Norfolk Boreas Offshore Wind Farm Applicant's Comments on Deadline 10 Submissions and Other Submissions (Tracked Changes)

Applicant: Norfolk Boreas Limited
Document Reference: ExA.ASR.D12.V2
Deadline 12

Date: May 2020
Revision: Version 2
Author: Royal HaskoningDHV

CAWSTON HIGH STREET - INTERVENTION SCHEME  
Scale 1:500

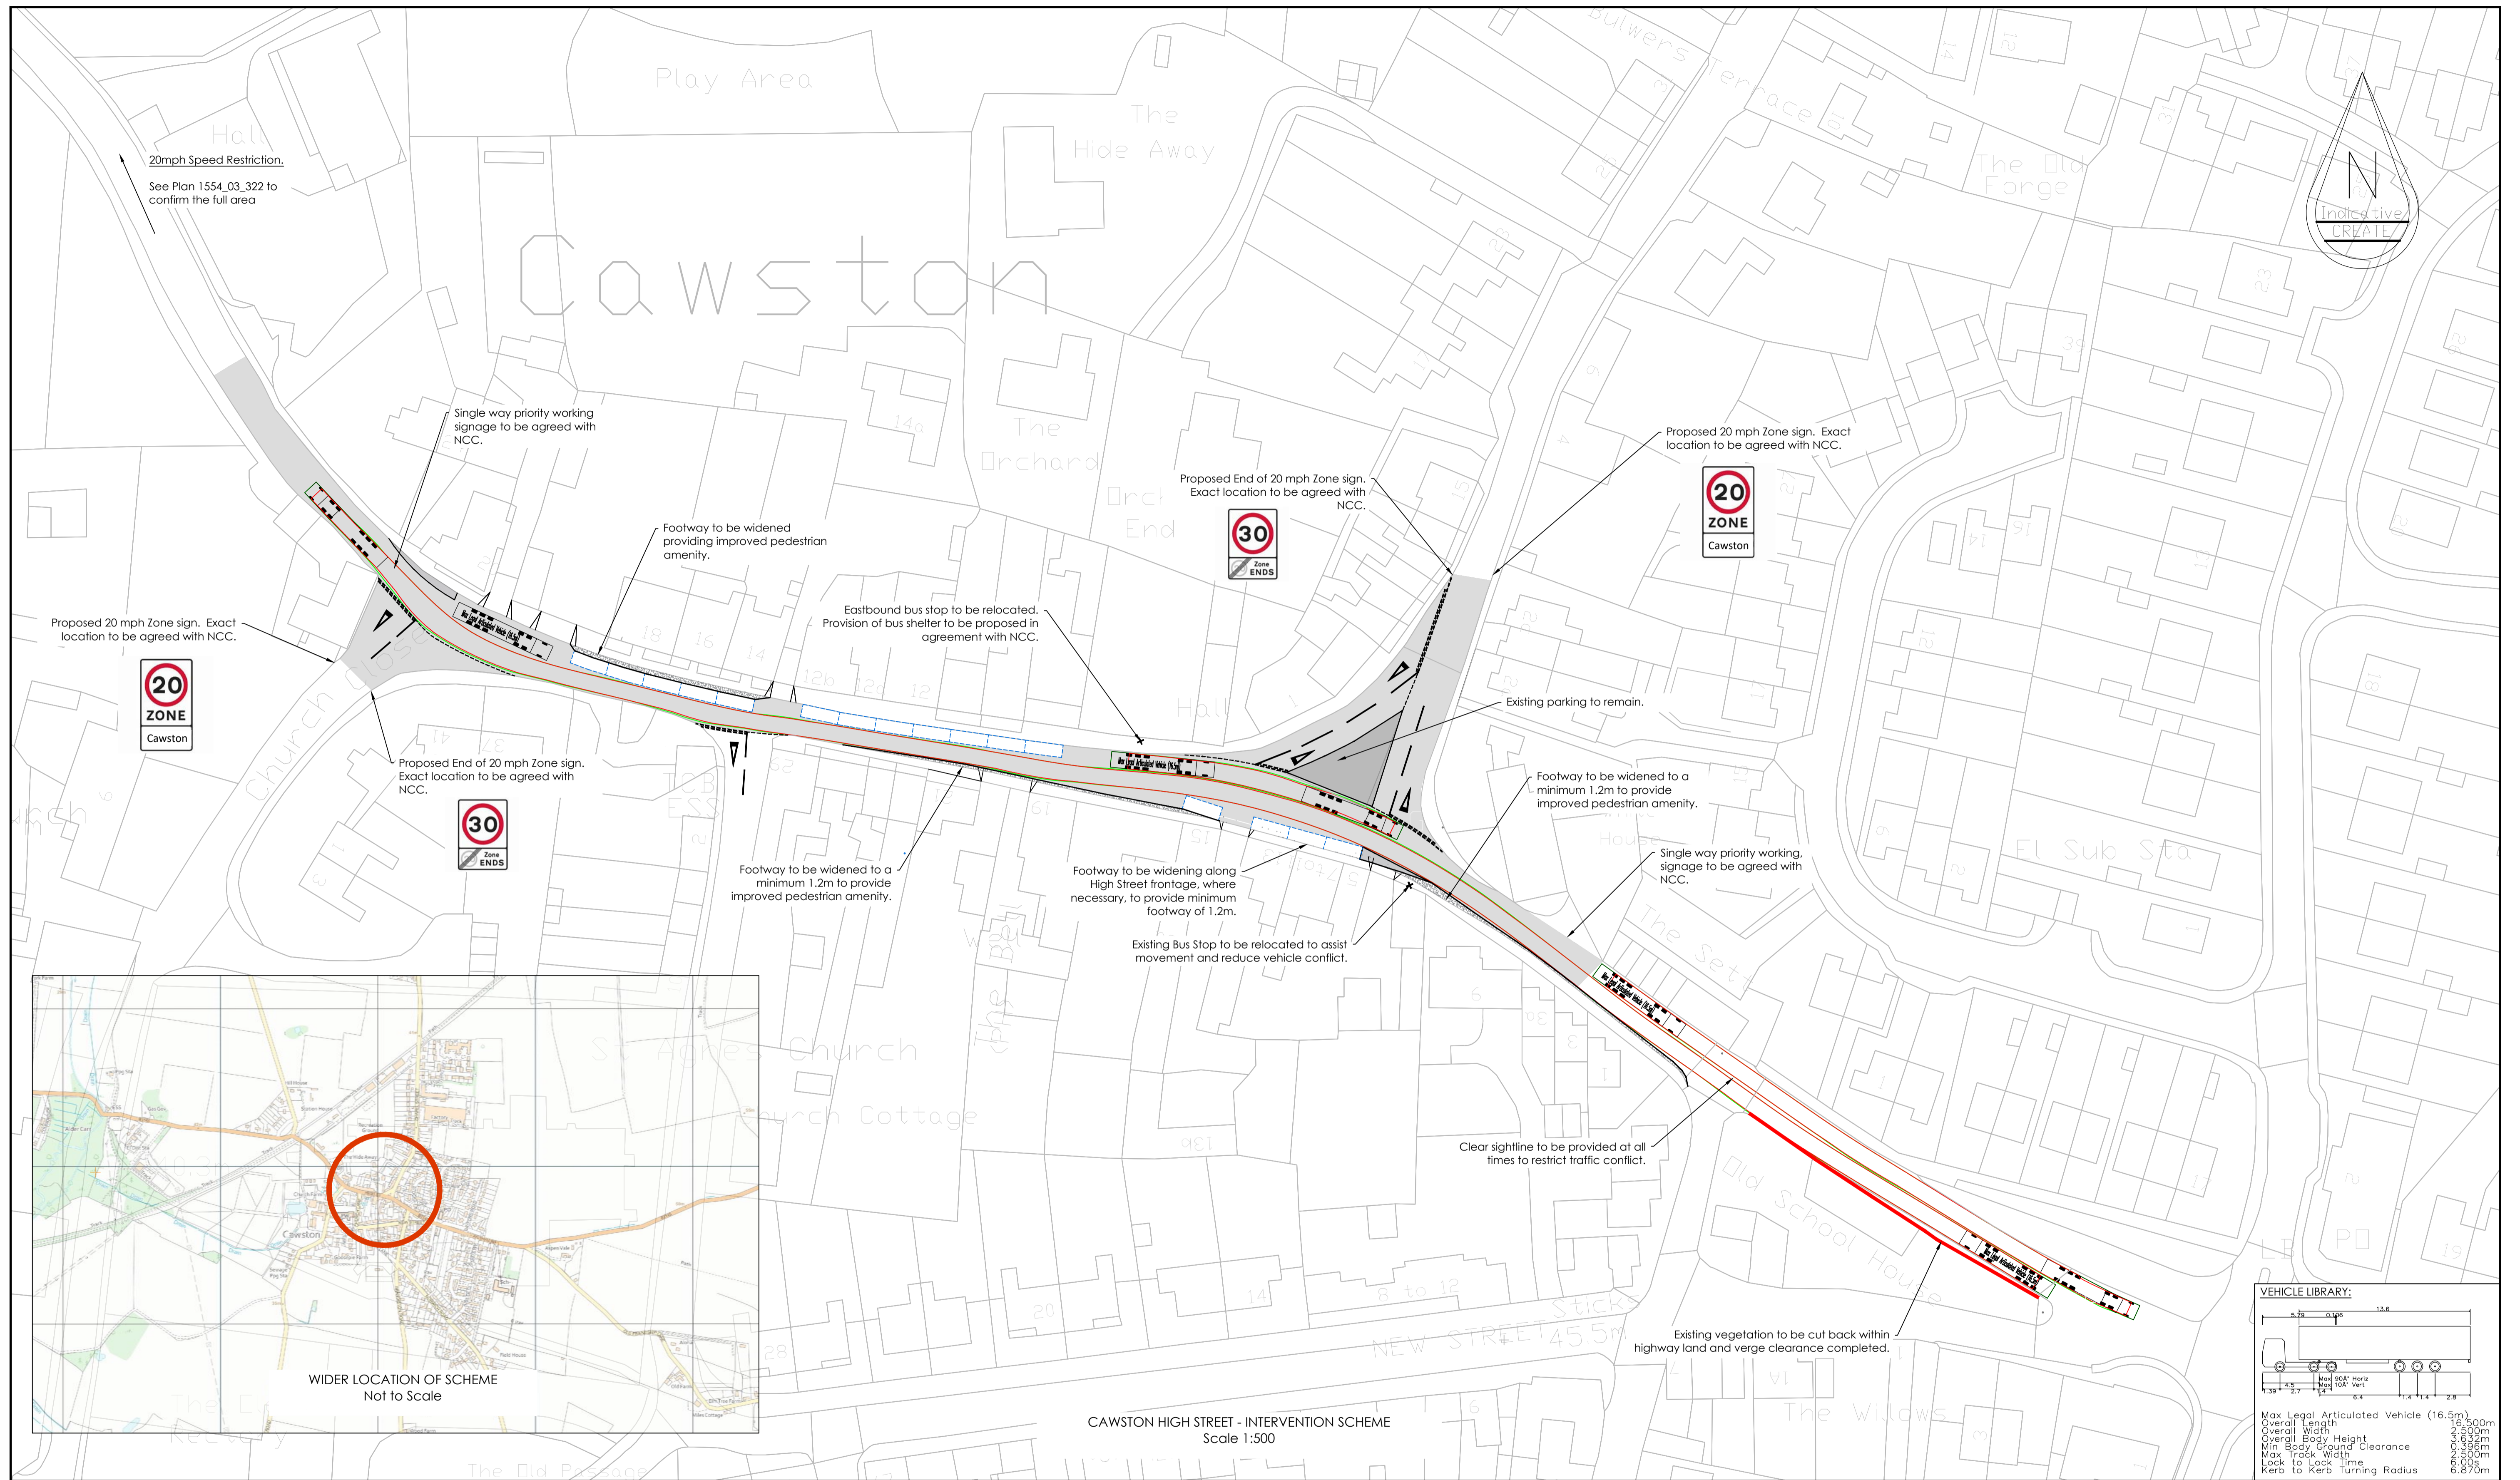
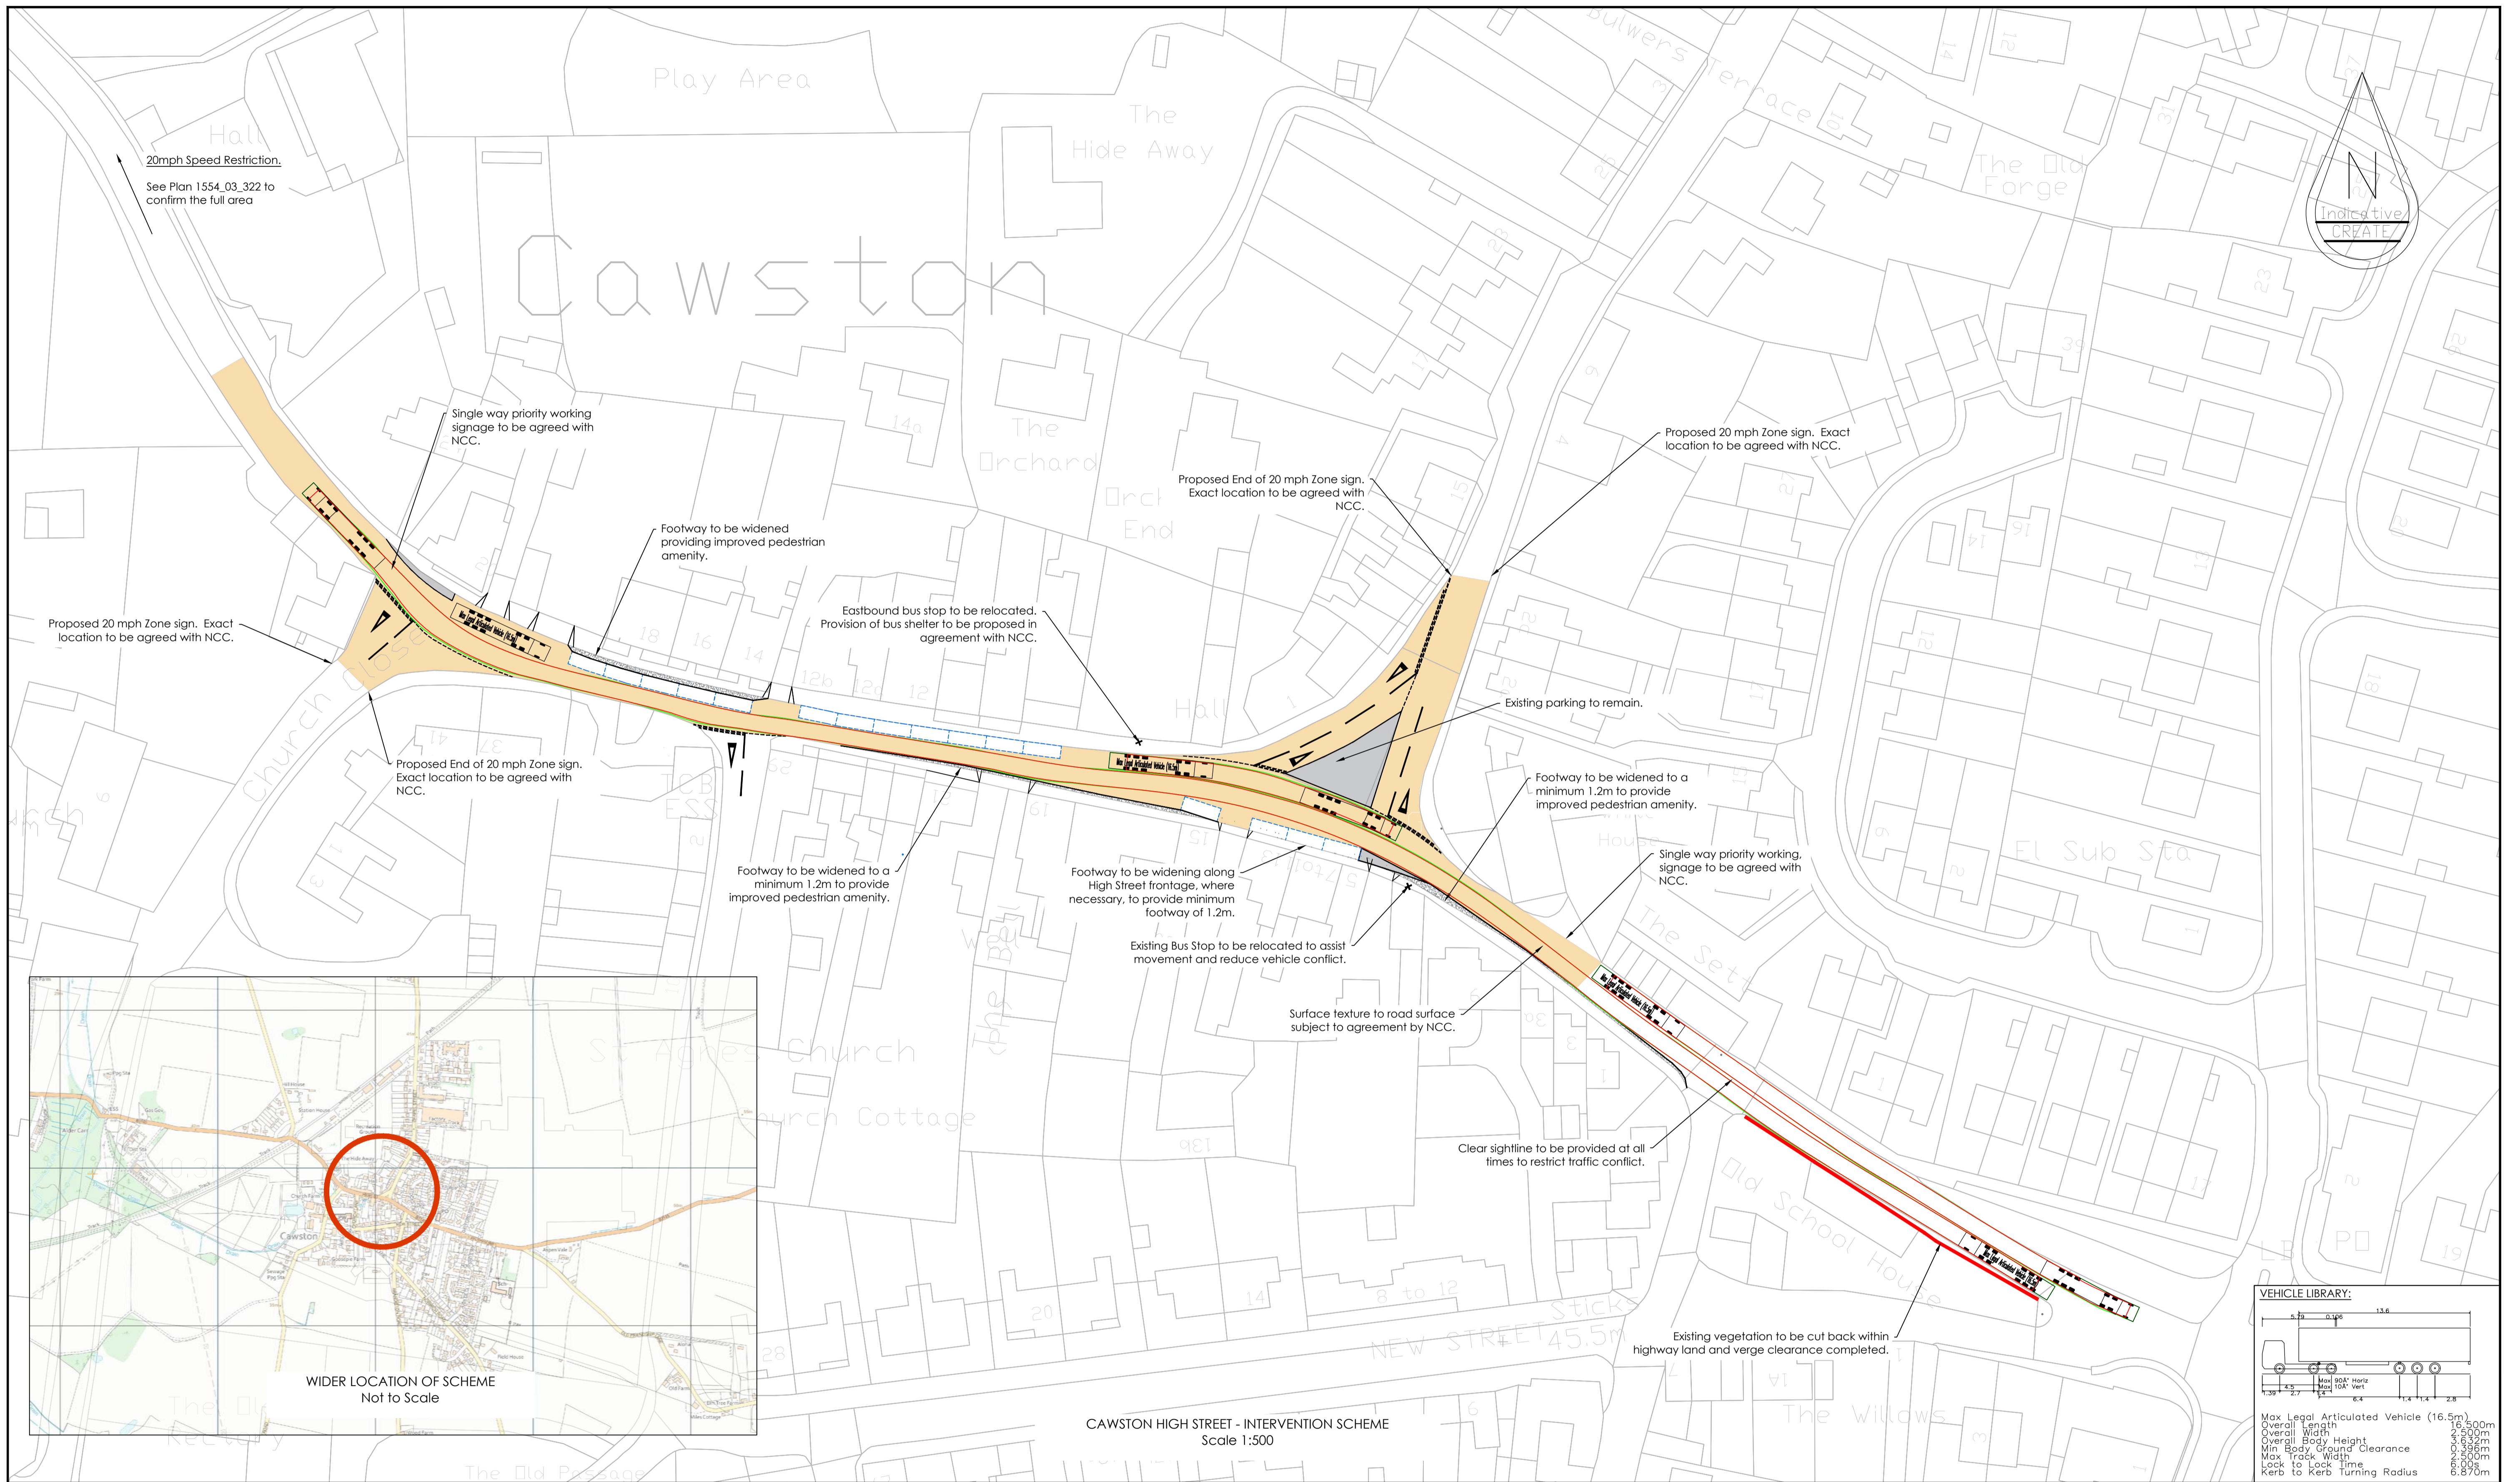
Summary of Submission	Applicant's Comments
<p>The additional width of vehicles from wing mirrors is not shown in the drawings and even in the areas designated for passing the additional width for two sets of wing mirrors and a safe passing distance between them is not evident.</p> <p>Cawston Parish Council views the proposed HIS to be flawed and impractical. For the scheme to have any hope of operating as designed a number of conditions need to be satisfied which include:</p> <ol style="list-style-type: none"> 1. The ability of all HGV drivers to be able to see oncoming traffic around corners on the bend at the railway bridge, on the bend by the Old Forge and on the bend close to White House Farm 2. A requirement for all HGVs, not only the Applicant's and/or Hornsea 3 project HGVs, to arrive at evenly spaced intervals 3. Where two HGVs approach from either East or West they must not have any other road traffic between so they can fit in the proposed system of "passing places". Any train of vehicles longer than the planned "passing space", which is designed for two HGV lengths, will obstruct passing manoeuvres and make gridlock more likely. <p>Norfolk County Council echoes some of CPC's concerns. The Applicant's Statement of Common Ground with NCC states that:</p> <p>NCC have raised a concern with regard to driver compliance, drivers may potentially fail to yield at pinch points causing traffic to back up, inducing unacceptable delays.</p> <p>In their letter of 27th April (REP8-036) NCC also reiterate their concerns that the HIS could fail</p> <ol style="list-style-type: none"> 1. If parking occurs outside the designated parking areas 2. Traffic fails to yield at the correct points 3. Or if traffic speeds are much higher than 20mph. <p>Residents of Cawston already see all three of these conditions on a daily basis, and our D6 submission (REP6-042) noted official Government sources showing that 20mph limits</p>	<p>Narrow footways</p> <p>[REP5-055] Revised Cawston Highway Intervention Scheme Road Safety Audit Decision Log ('RSA log') reports that the Road Safety Audit (RSA) recognises that the likelihood of pedestrian/vehicle conflicts has been reduced by the HIS key design principles of:</p> <ul style="list-style-type: none"> • Providing adequate road space for HGVs to traverse the High Street without the requirement to mount or project over the pavement; • Protecting adequate road space for the HGV routes with the introduction of formal parking controls; • Advance sign warning of 'pinch points'; and • The introduction of a mandatory 20mph limit. <p>The RSA notes there may be a residual perceived risk to pedestrians and makes the following recommendations:</p> <ul style="list-style-type: none"> • Introduce measures to highlight the presence of pedestrians within the area; • Introduce road markings and 20mph signage at the gateways allowing for maximum impact and awareness; • Provide maximum footway area, by attaching all signs to existing street furniture where possible and introducing any new signposts to the back of the footway, reducing footway clutter. • Review the compliance of drivers following the introduction of the reduced speed limits and introduce further measures if necessary. <p>The Applicant has accepted all of these recommendations and has incorporated them into the finalised HIS design (detailed in the OTMP [REP10-016]. The Applicant therefore reiterates the conclusion of the RSA log [REP5-055]:</p> <p><i>"Following the evaluation of the key effects that are likely to influence pedestrian risk it is concluded that the likelihood and severity are low and</i></p>

Summary of Submission	Applicant's Comments
	<p>a 20mph speed limit to enable HGV drivers to safely react to the highway environment and 'yield' to oncoming HGVs as required.</p> <p>The HIS design has been informed by a full topographical survey and demonstrates the swept path simulation of the largest UK standard HGV; a 44t articulated tractor and semi-trailer, 2.55m wide trailer, 2.49m cab width and 0.25m wide wing mirrors.</p> <p>In respect of HGV arrival/regulation, the HIS scheme design has been developed to accommodate an even arrival profile for the Project's HGVs (the management of which is secured in the OTMP [REP10-016]) and a random arrival pattern for non-Project HGVs.</p> <p>An intensive monitoring regime and further driver compliance intervention measures were introduced at Deadline 8 in the Outline Traffic Management Plan (V4) [REP8-008] to accommodate the RSA recommendations. In addition, in response to NCC's request for clarification, the text has been refined, as agreed with NCC, and is included in the OTMP (Version 5) submitted at Deadline 10 [REP10-016]. Agreement is confirmed in both the final Statement of Common Ground with Norfolk County Council (Version 3) [REP9-015] and the Applicant's Joint Final Position Statement with Norfolk County Council Highway Intervention Scheme, Cawston (ExA.AS-1.D11.V1) to be submitted at Deadline 11. The range of measures to enable targeted intervention on validation of a driver compliance issue are as follows:</p> <ul style="list-style-type: none"> • Applying the OTMP 'breach' corrective process identified in Section 5.4 and 5.5 to the supply chain; • Further hazard signing; • Introducing mandatory priority 'give-way'; • Increased parking enforcement; • A reduction in the cumulative HGV cap (239 HGV movements) by ensuring Norfolk Boreas and Hornsea Project Three traffic demand does not overlap; and • Incrementally reducing the volume of traffic passing through Cawston from 239 HGV movements through targeted intervention
